**From:** Chris Moore  
**Sent:** 18 June 2020  
**To:** Sian Eggington  
**Subject:** RE: Request for further information BR/123/20/HH  
**Attachments:** We sent you safe versions of your files; Prop Elevations 1.pdf

CIL: The CIL date is too old. Please amend or with your permission we can amend for you. -- Revised copy sent previously.

EXISTING ELEVATIONS

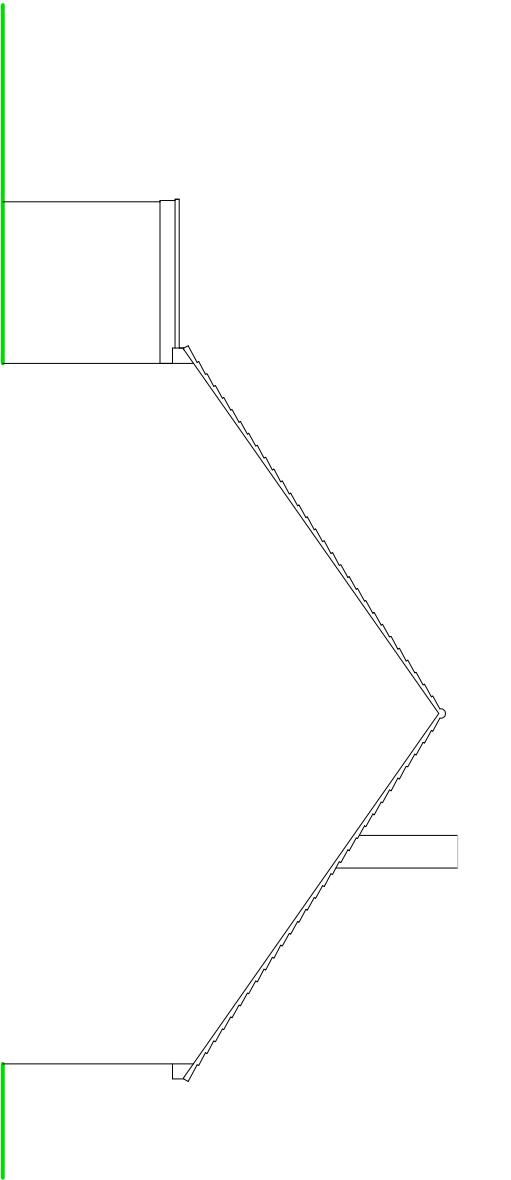
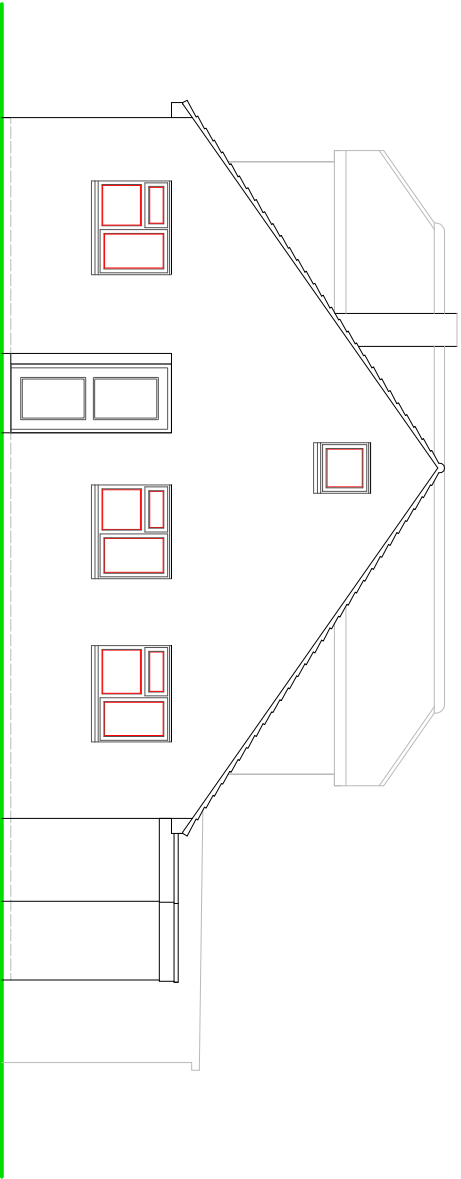
Confirmation Required: The existing side elevation is showing a dormer, please confirm whether this is showing a neighbours dormer. -- Yes, that is next door's dormer.

Thank you for your email, please confirm whether the dormer shown on the existing side elevation is a neighbouring dormer. The existing shower room on the ground floor is also being split into a WC/utility the floor plan shows this affects the window being split from one large window to 2 x small windows however this has not been shown on the proposed side elevation. Please amend.

PROPOSED ELEVATIONS

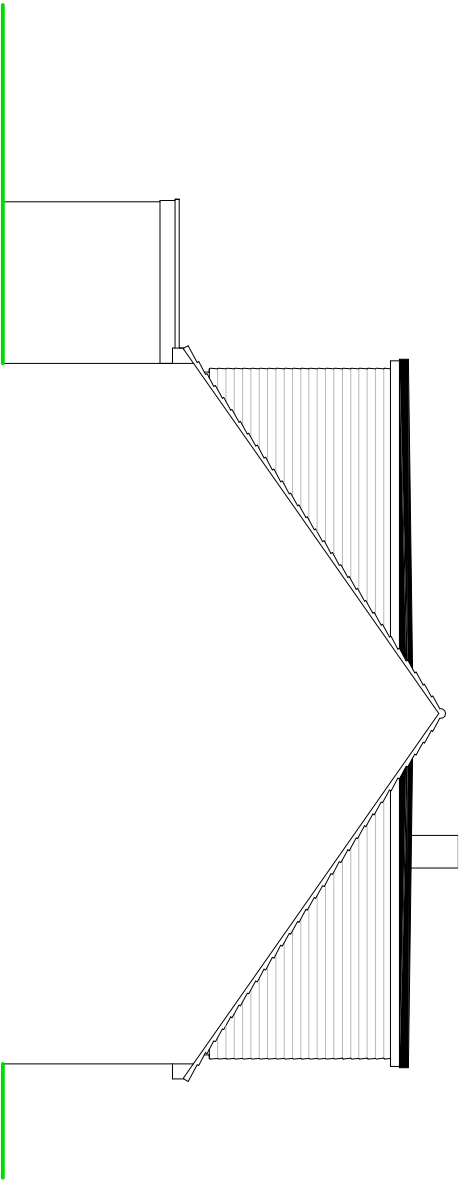
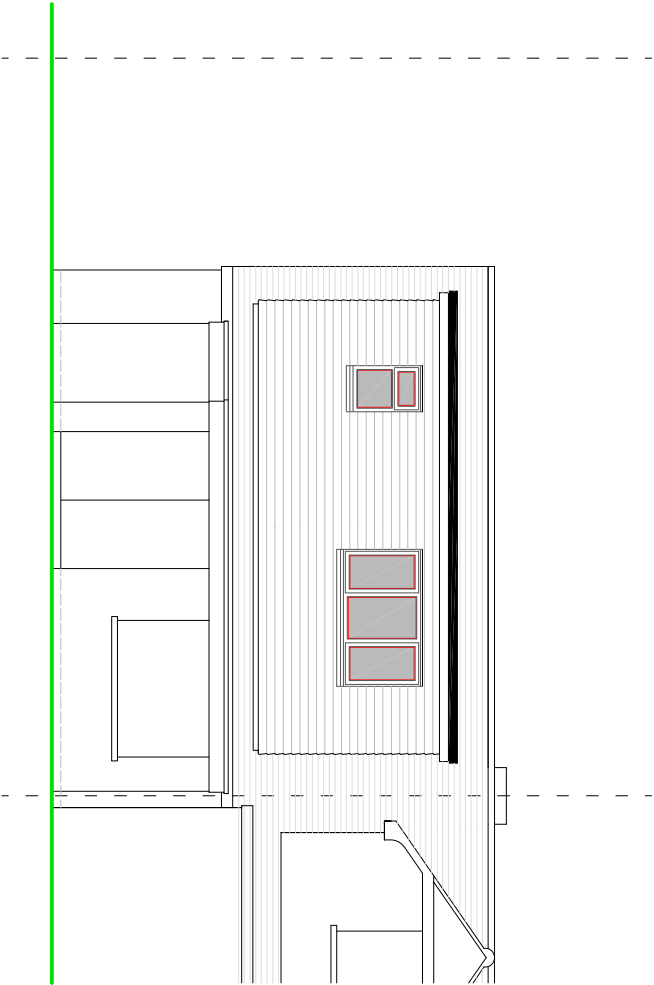
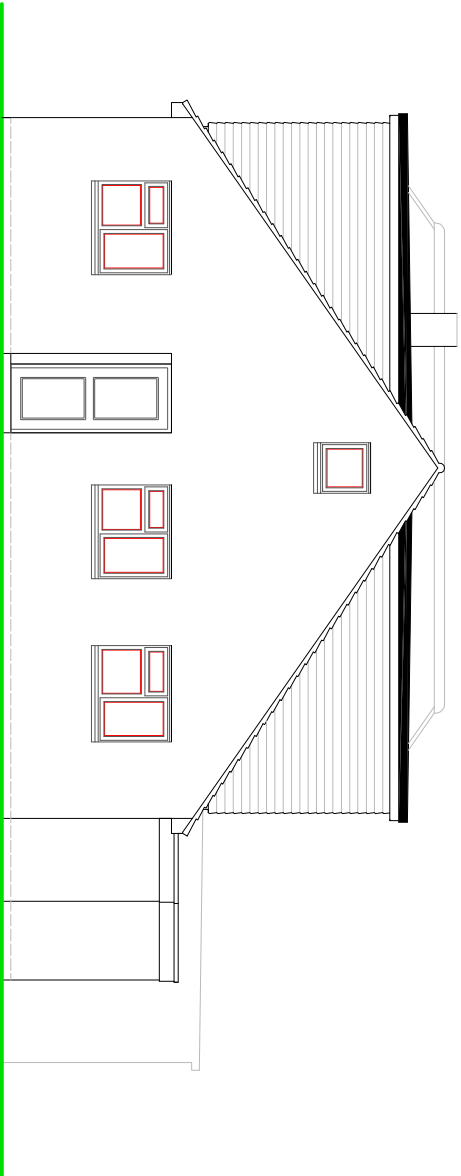
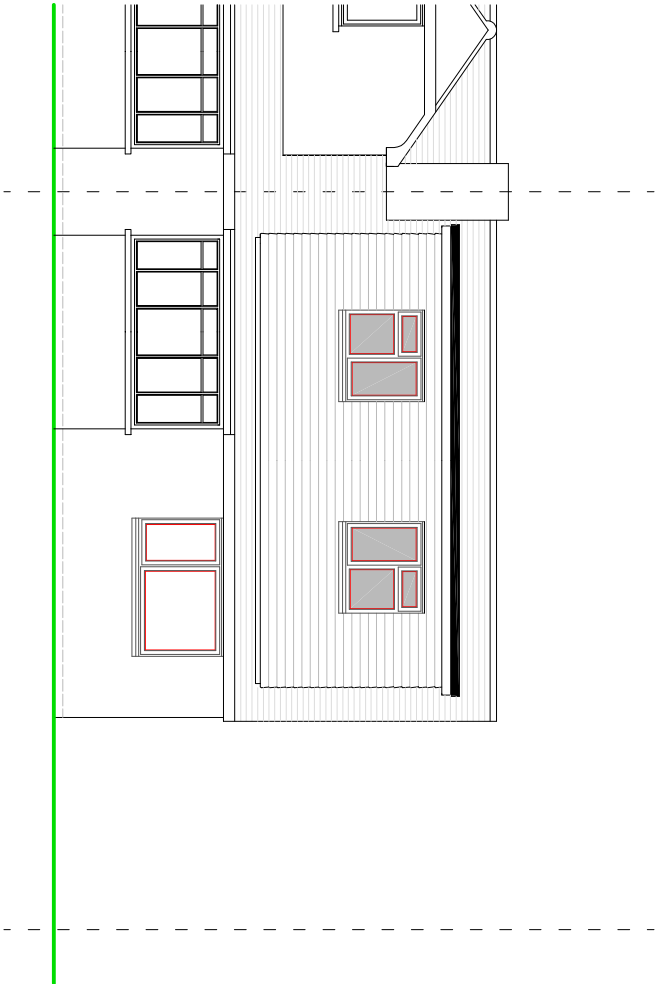
Plan: The windows are inconsistent between the proposed ground floor and side elevation. Please amend. -- windows adjusted on the attached elevation.
